Mountmellick Flood Relief Scheme An Coimisiún Pleanála Submission Response Note Case # ACP-323830-25

February 2026

This report relates to the Mountmellick Flood Relief Scheme commissioned by Laois County Council (LCC), on behalf of the Office of Public Works (OPW).

Figure 2-3: Undefended Scheme

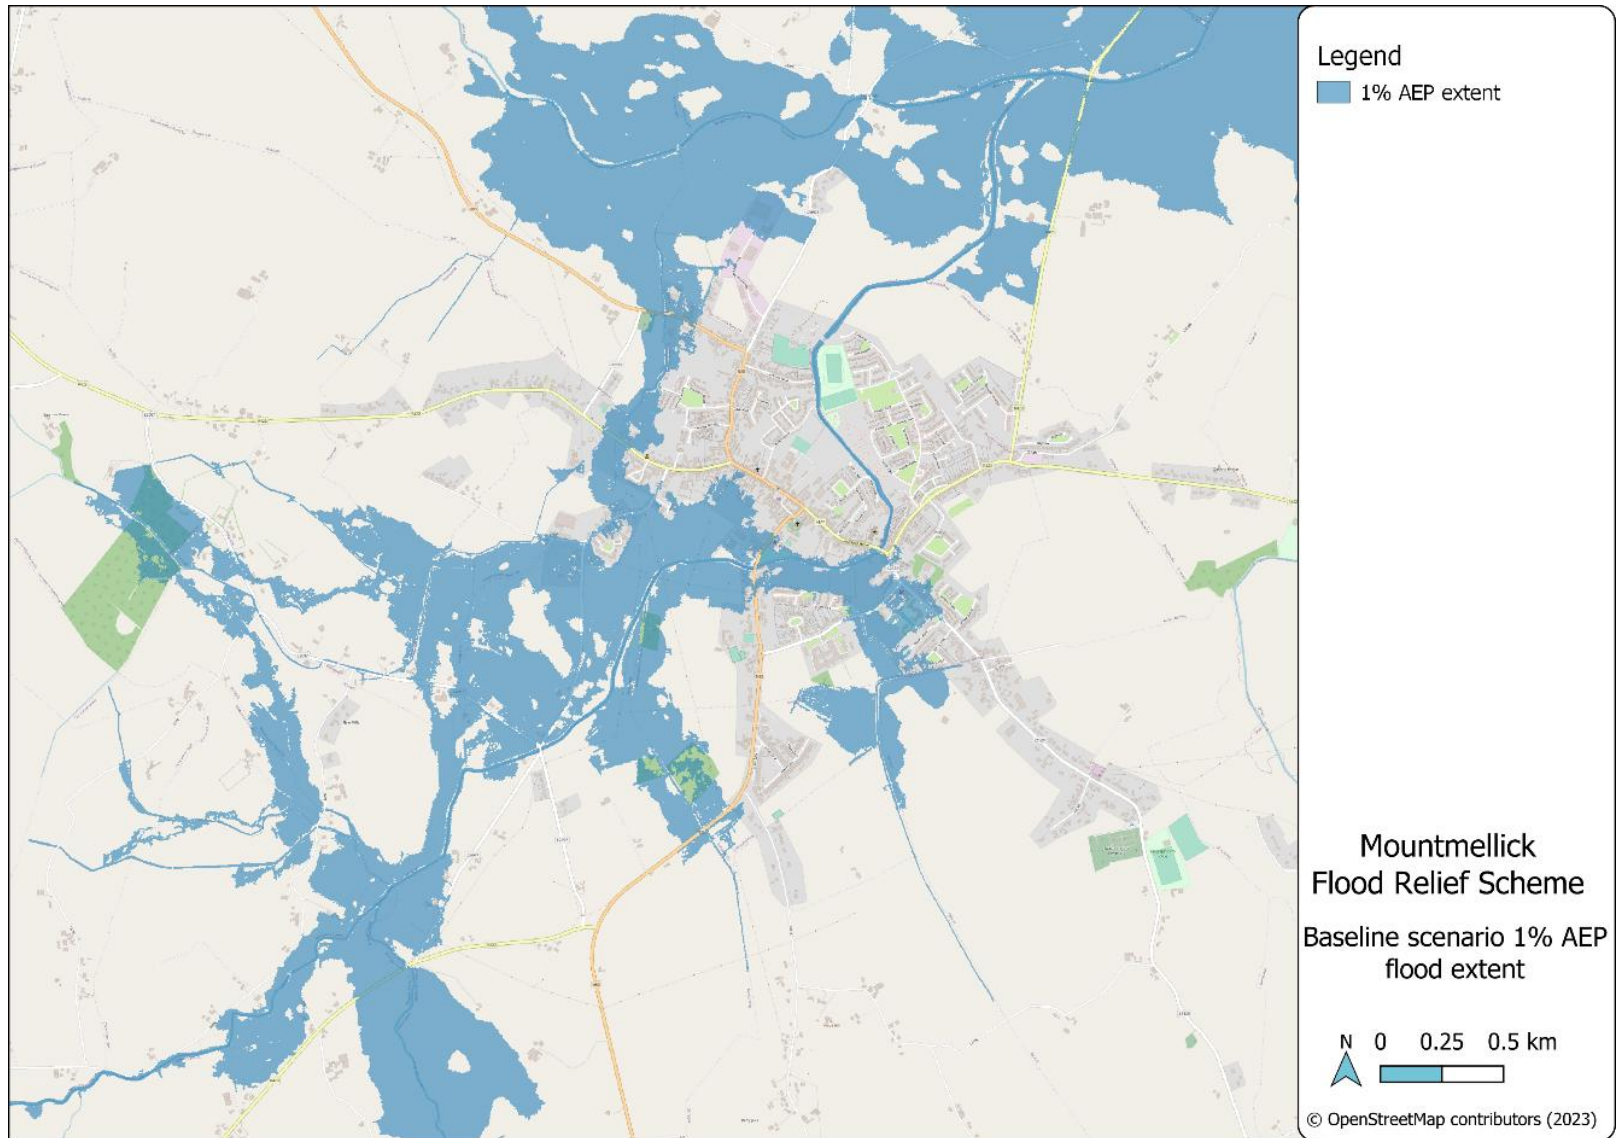
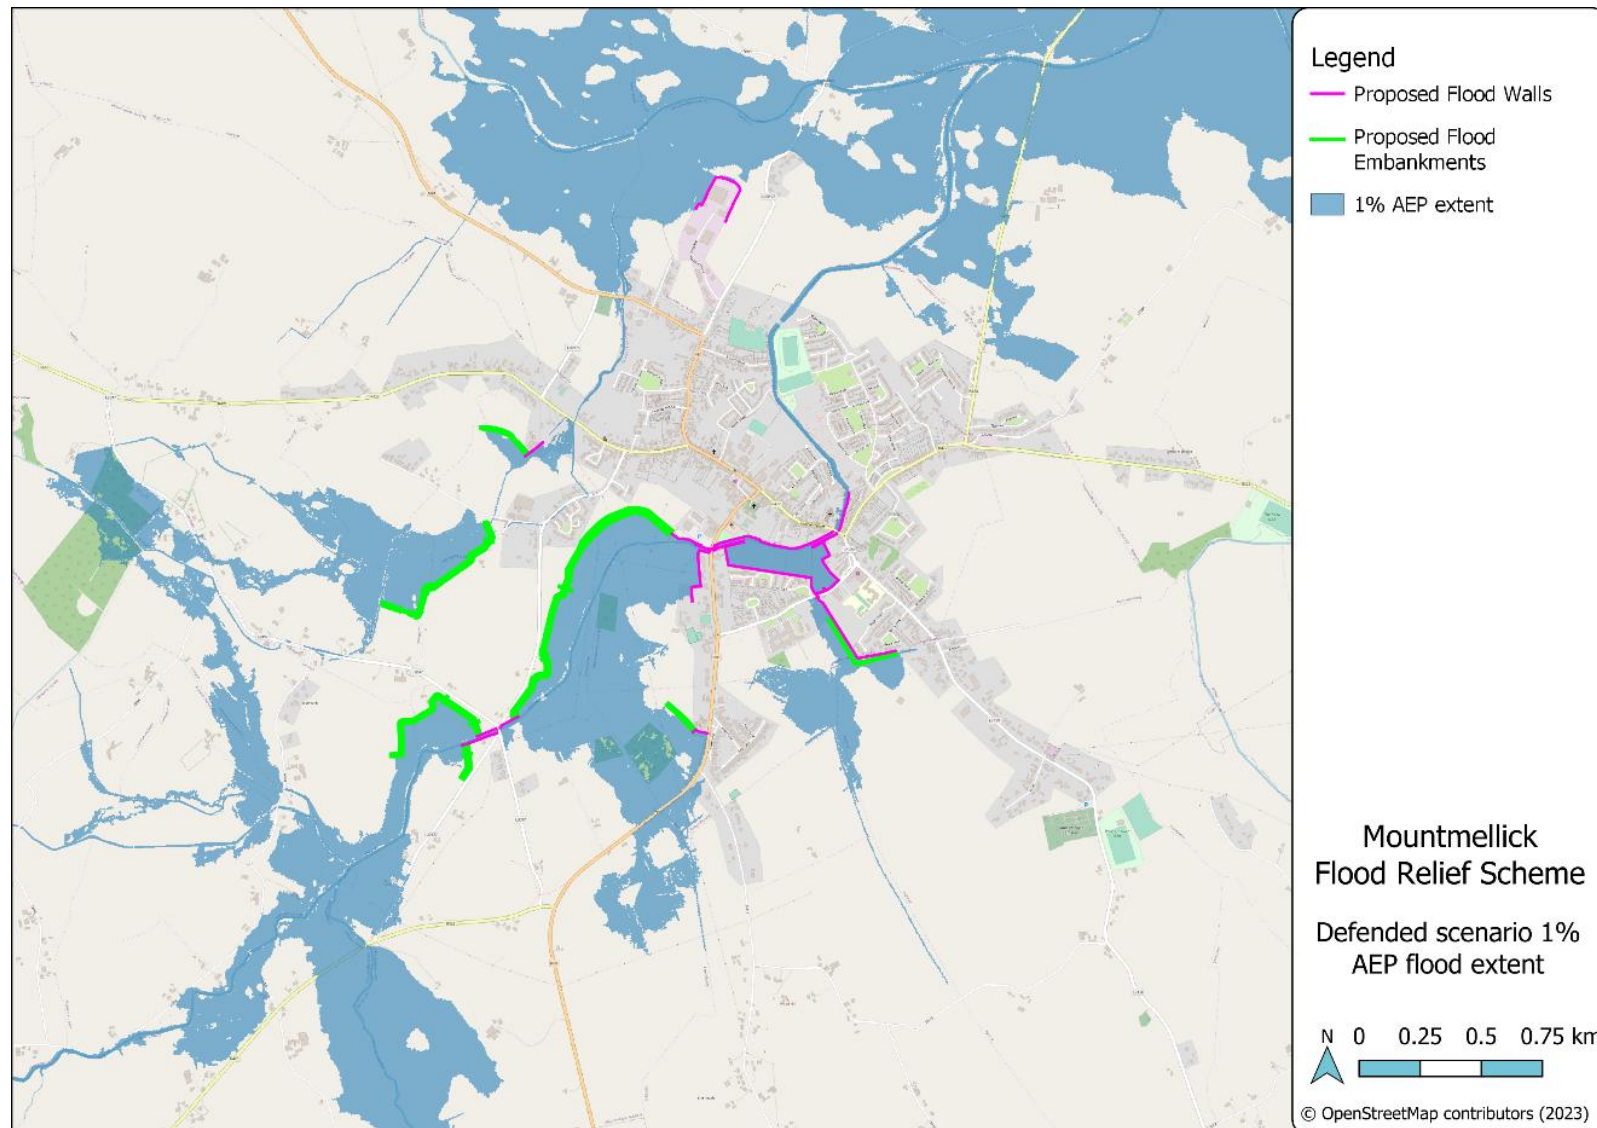
1. Require updated and complete hydraulic modelling and mapping to be submitted as part of the application, reflecting:
 - a. The latest agreed model for Derrycloney
 - b. Flood extents and depths for all six scenarios, with and without the FRS, clearly showing differences for both low bank and high bank properties.
2. Require the scheme promoters to demonstrate, with this updated modelling, that the FRS will not materially increase flood levels or risk to the high bank houses for at least:

- 1a. The latest agreed model for Derrycloney has been used in the development of the flood outline and planning design. Figure 2-3 in the AA and Figure 3-4 in the NIS (these are the same figures) show a slightly different profile in the field opposite the Derrycloney Residents. The revised figure is shown below in Figure 2-4.
